6th February 2012

**Department of Planning & Infrastructure
23-33 Bridge Street
SYDNEY NSW 2000**

**RE: EXHIBITION OF ENVIRONMENTAL ASSESSMENTS FOR
PEMULWUY MIXED USE DEVELOPMENT, REDFERN (MP06_0101
MOD 1 & MP11_0093)**

| TITLE | Lawson Street Bridge Works                                                                                              | DATE    | June 2010    |

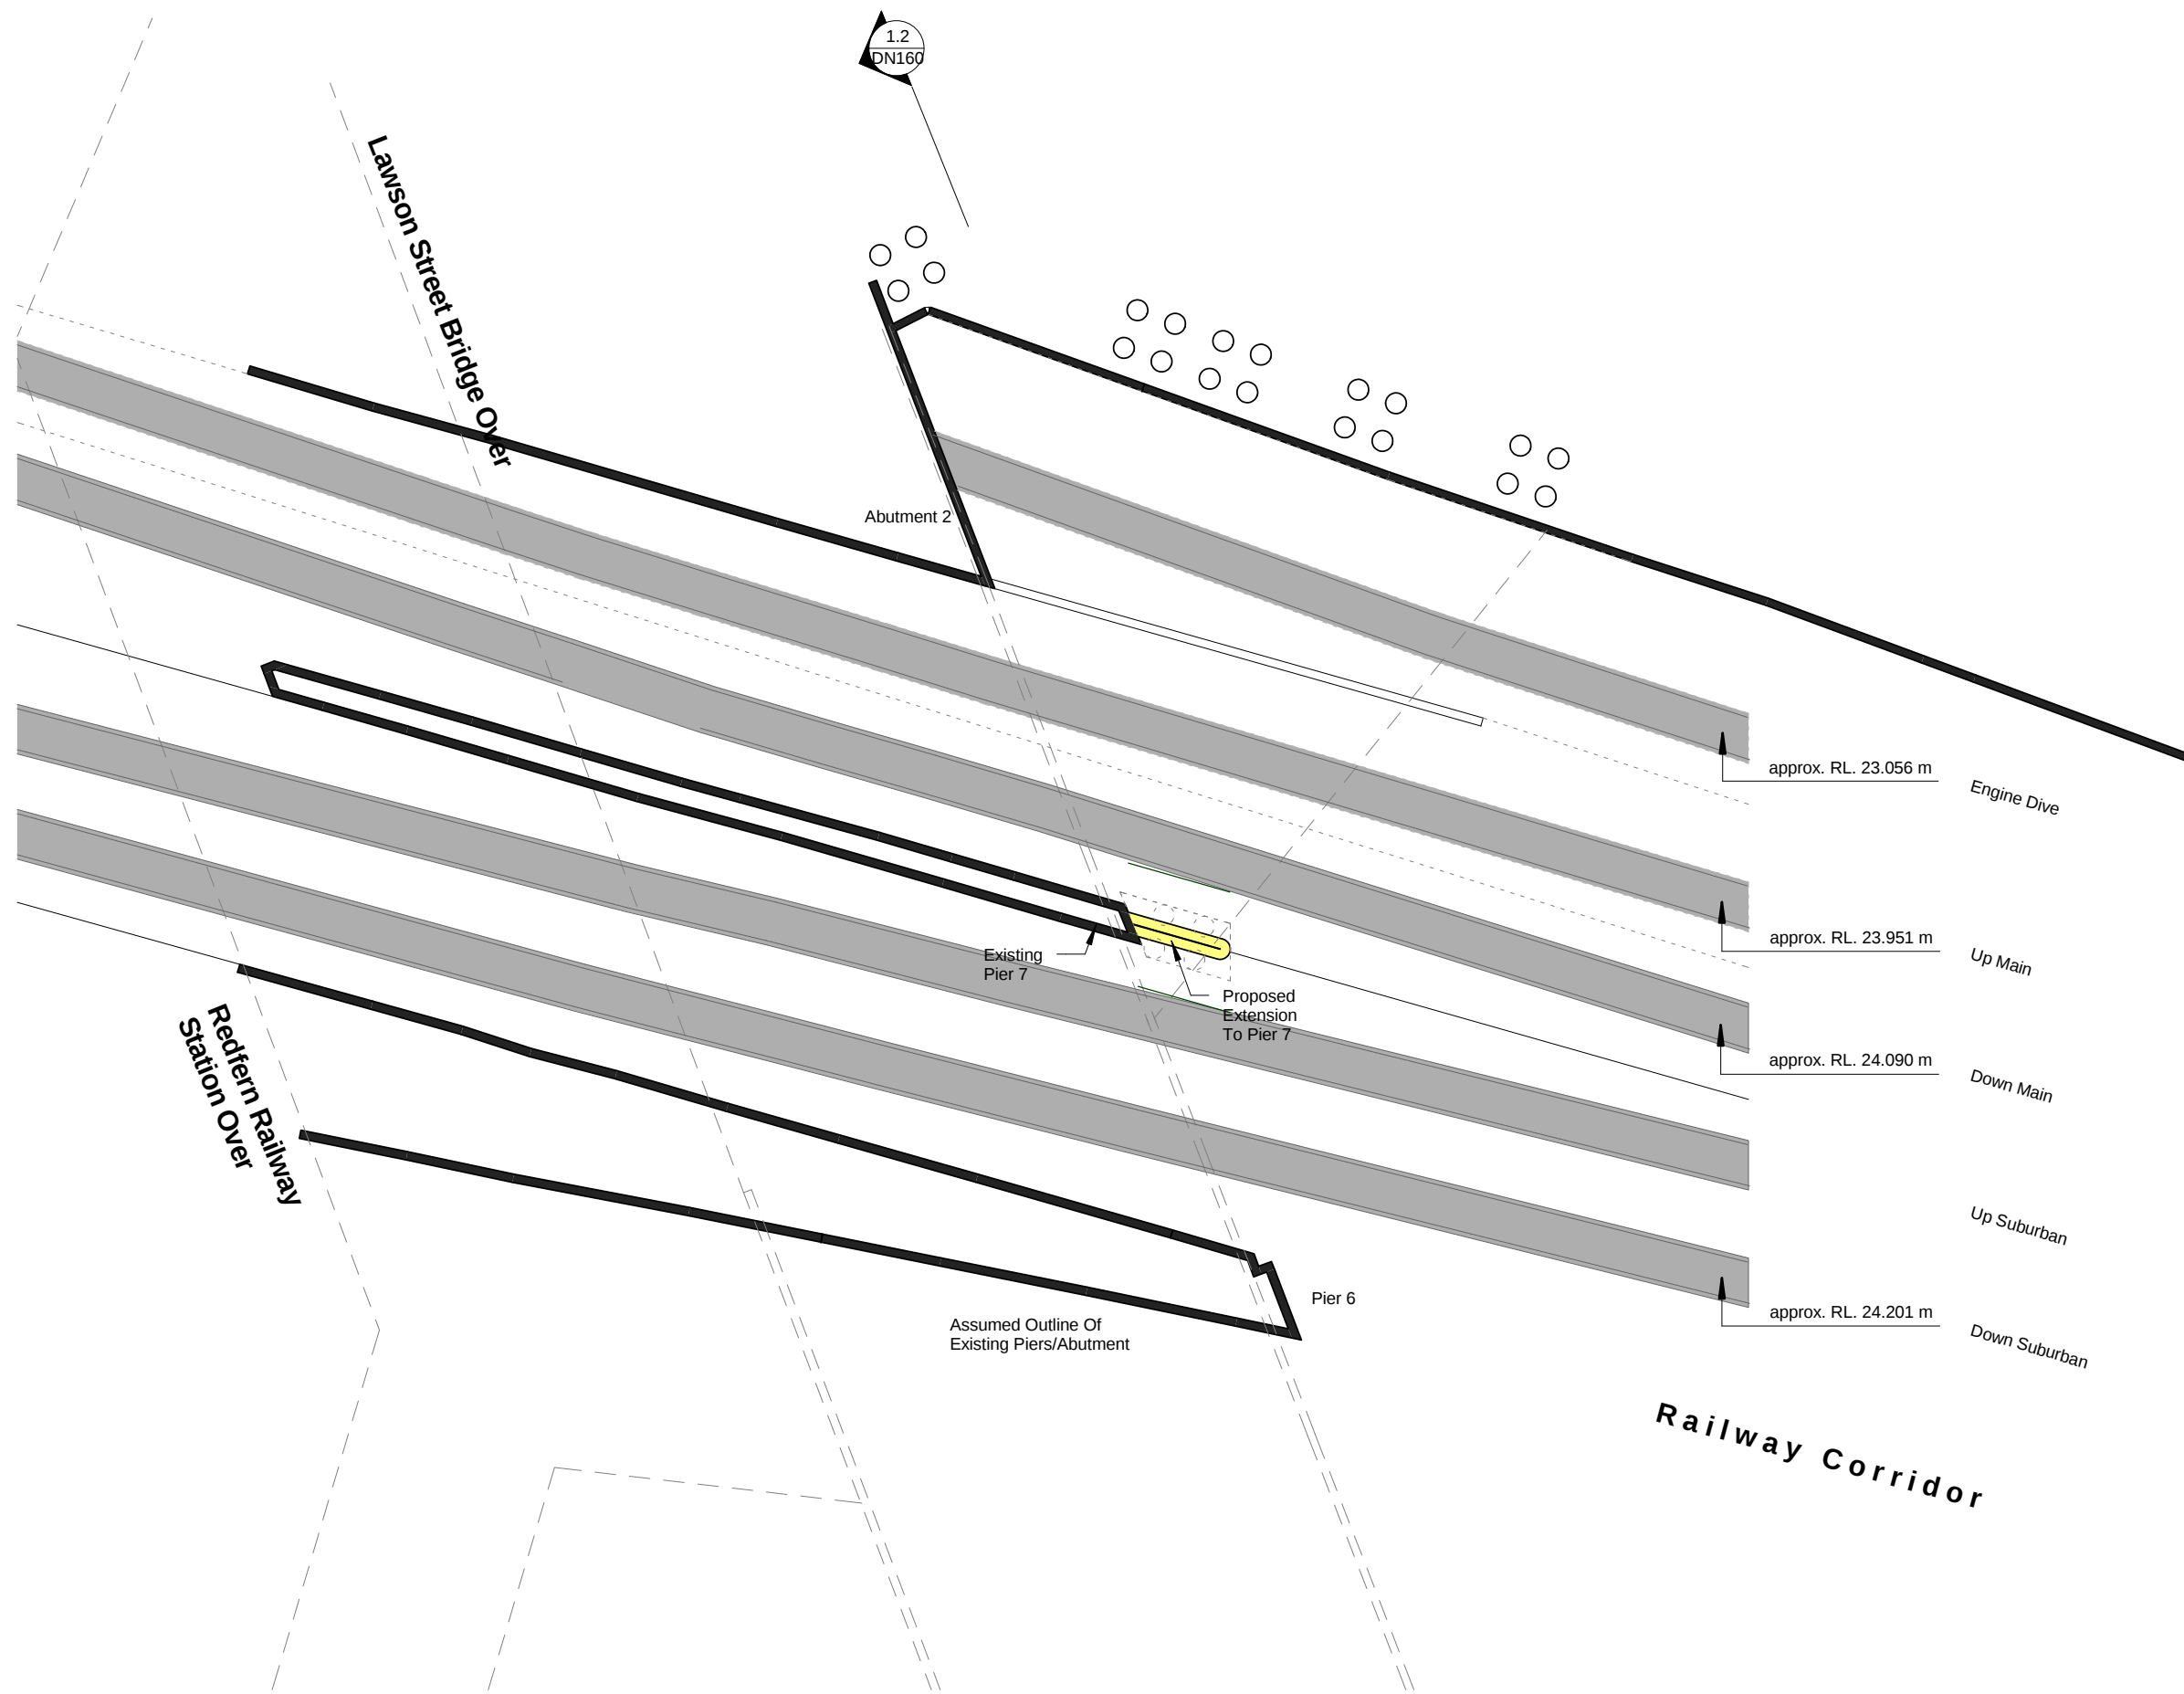
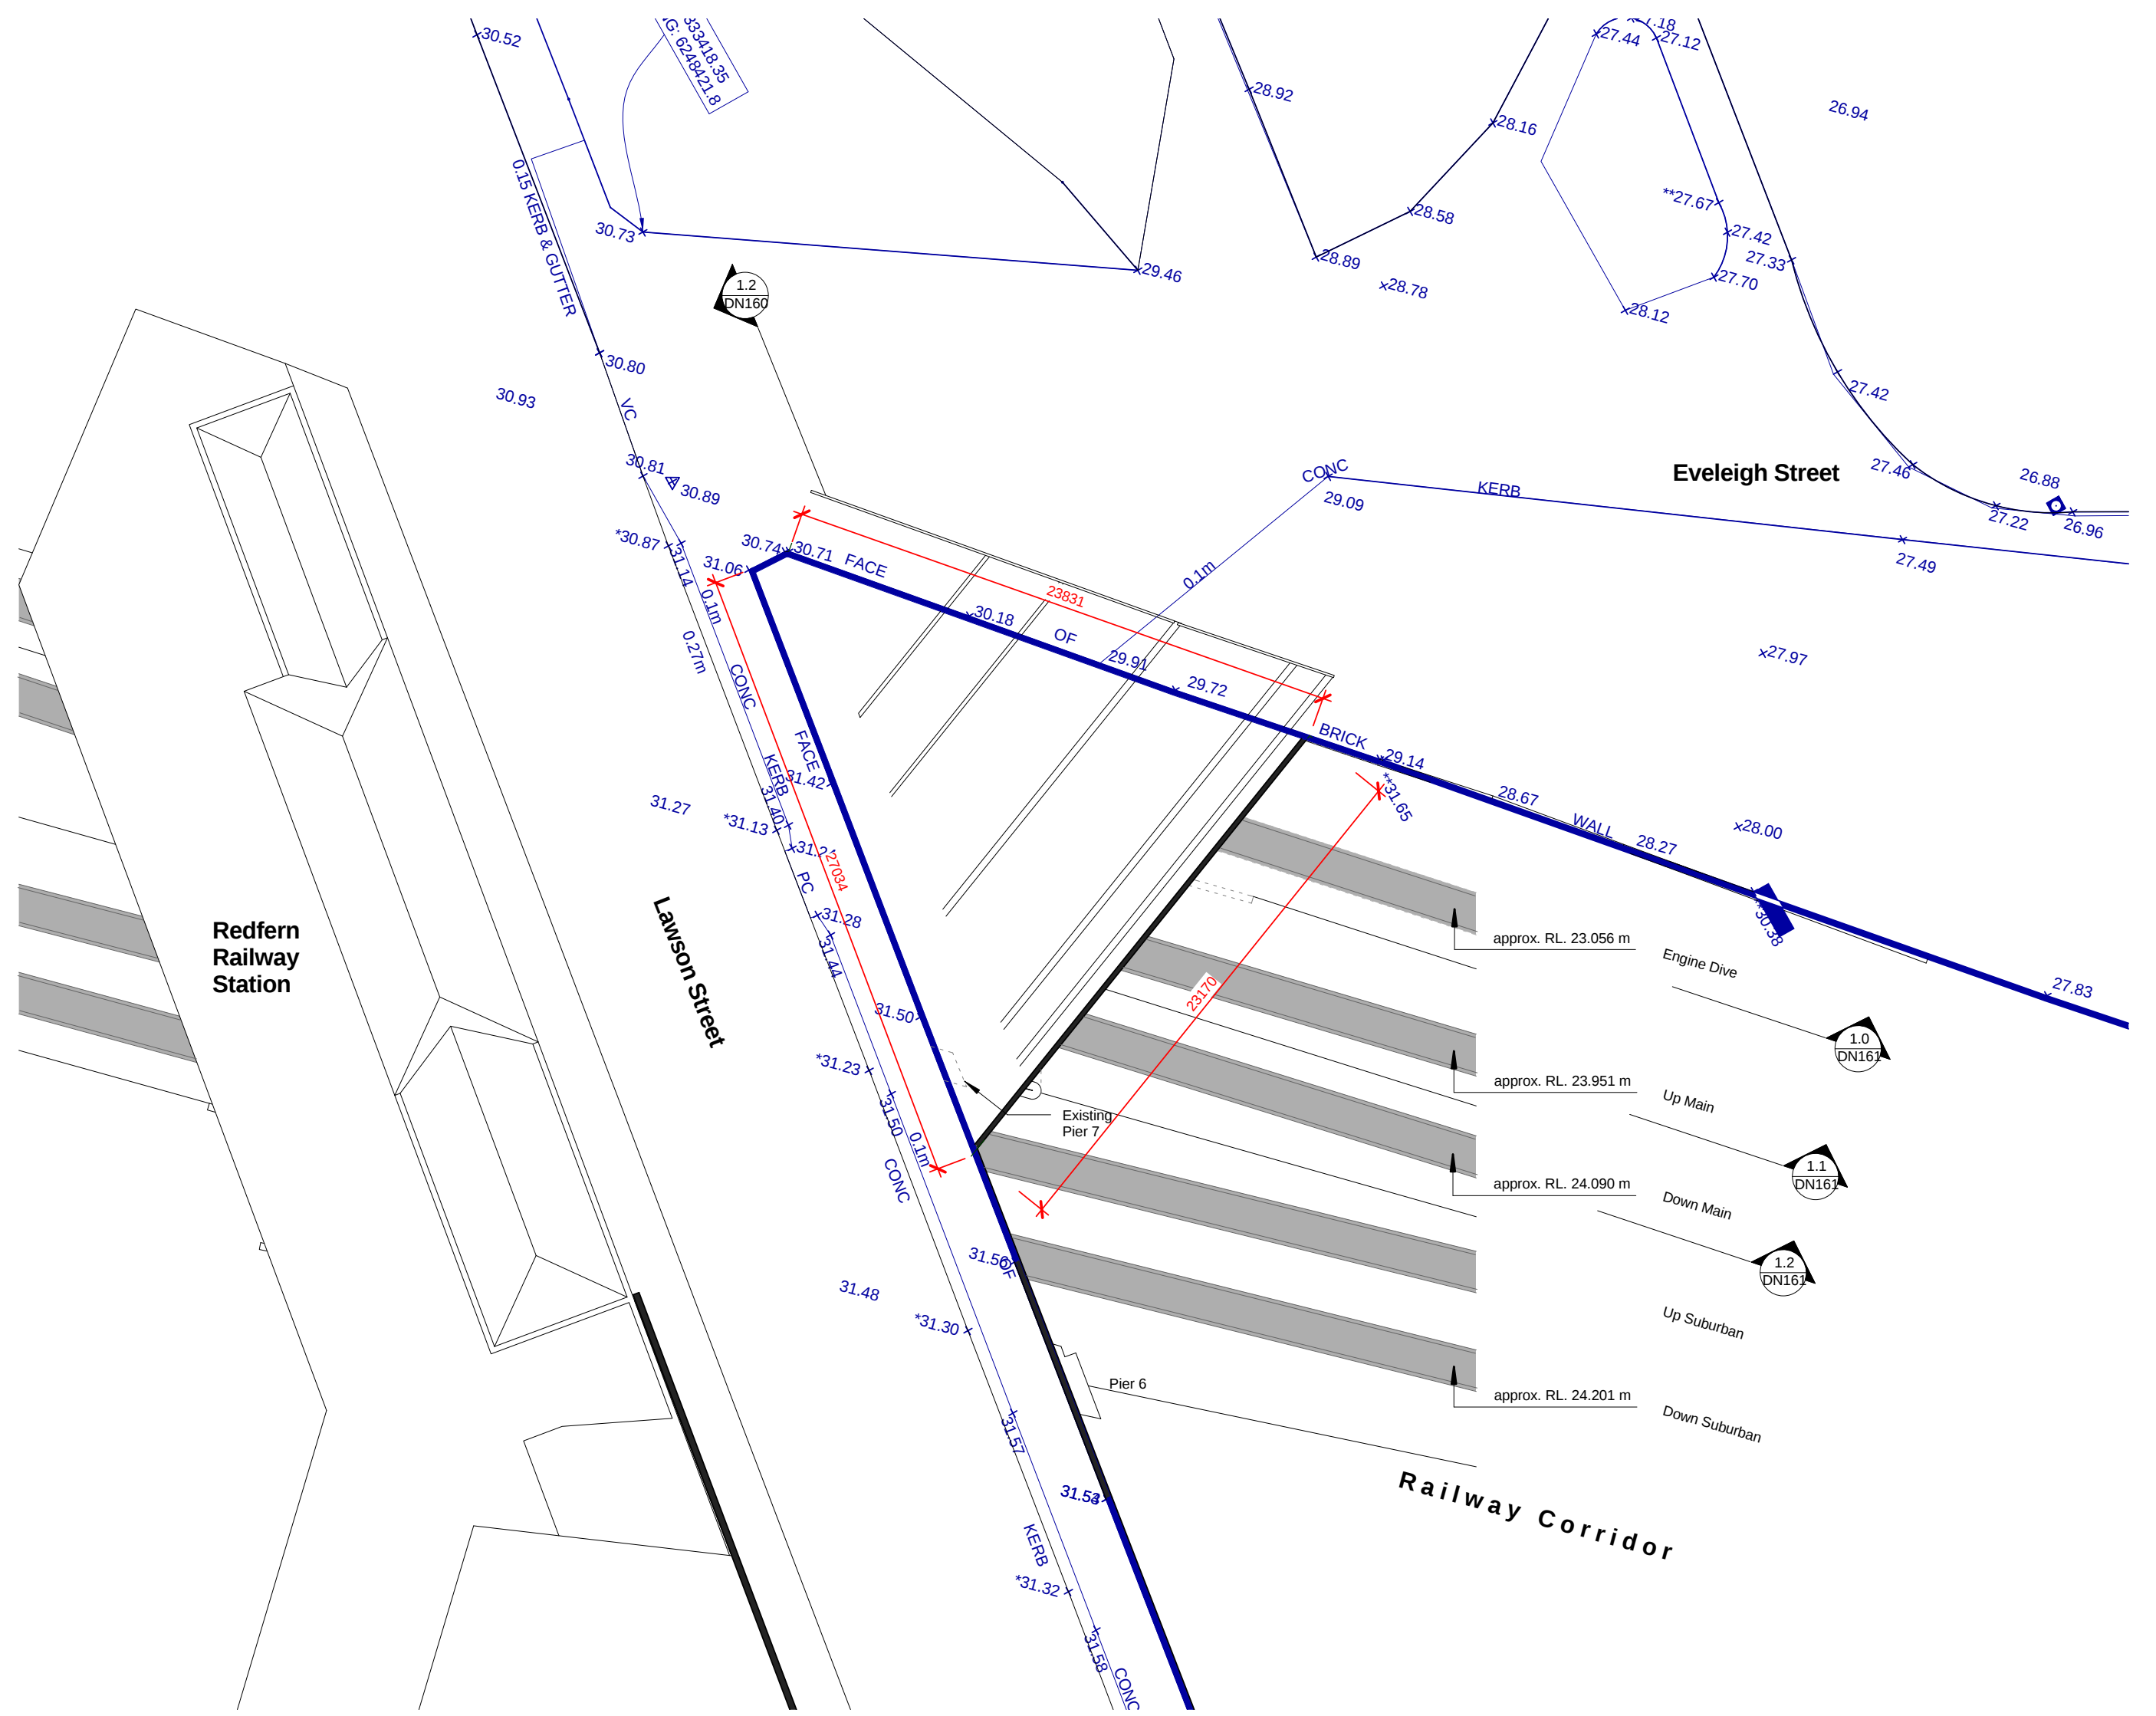
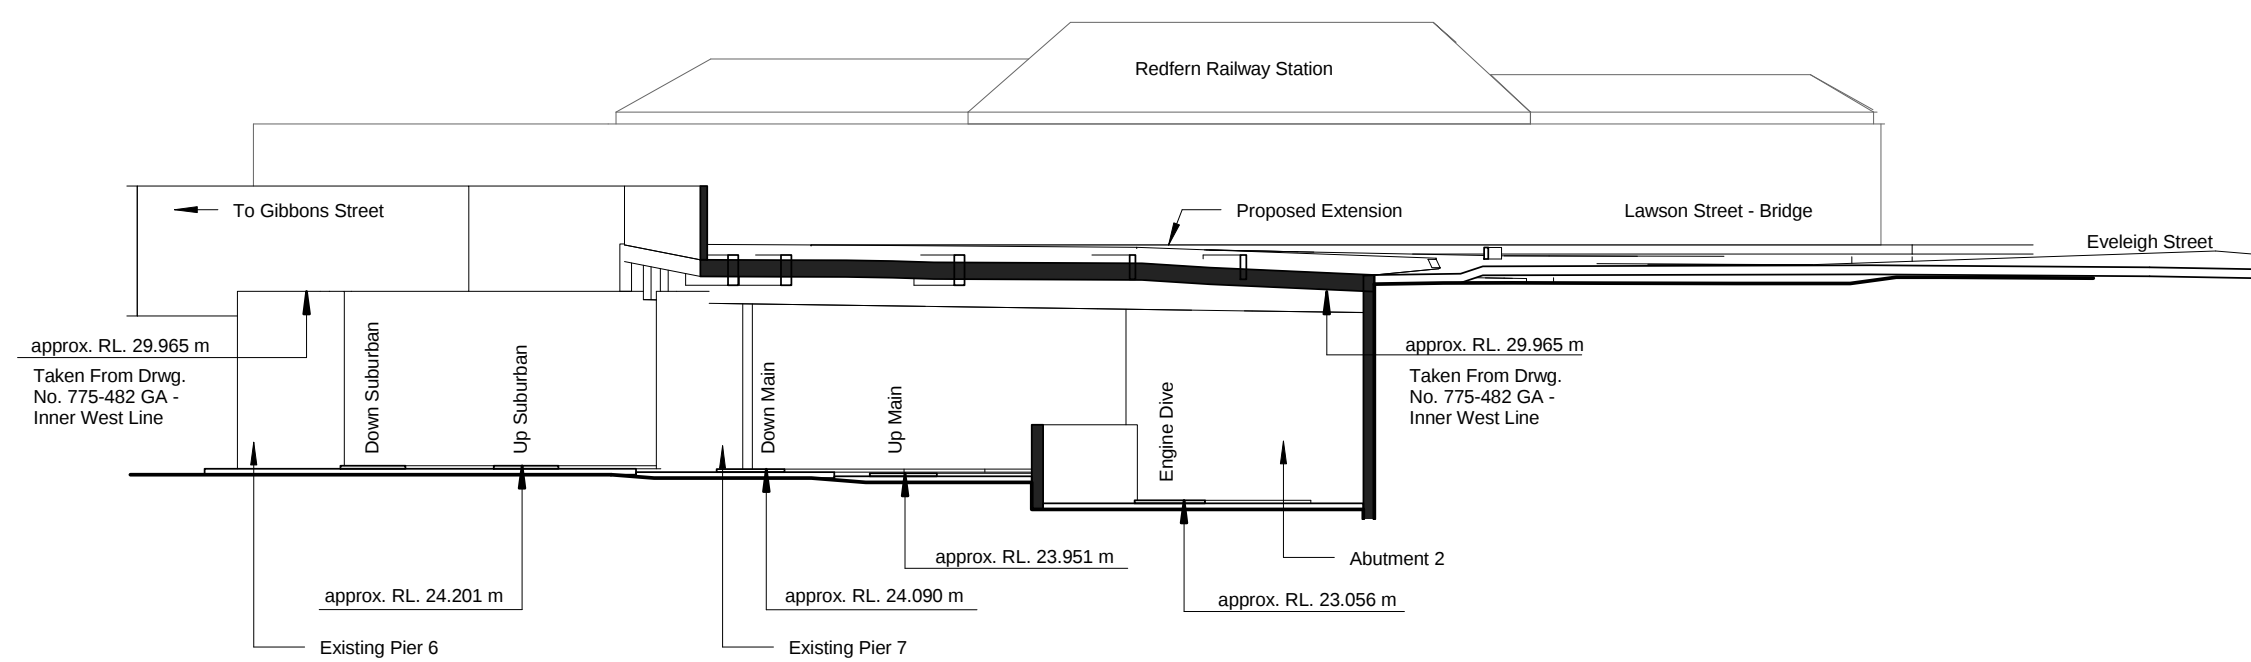
There are existing cables across the existing railway bridge which may require relocation during the extension of the existing bridge.

Ausgrid would require conduits across the new section of the bridge for future cable crossings. Ausgrid would require a minimum of 8 by 150 mm conduits to be installed across this bridge
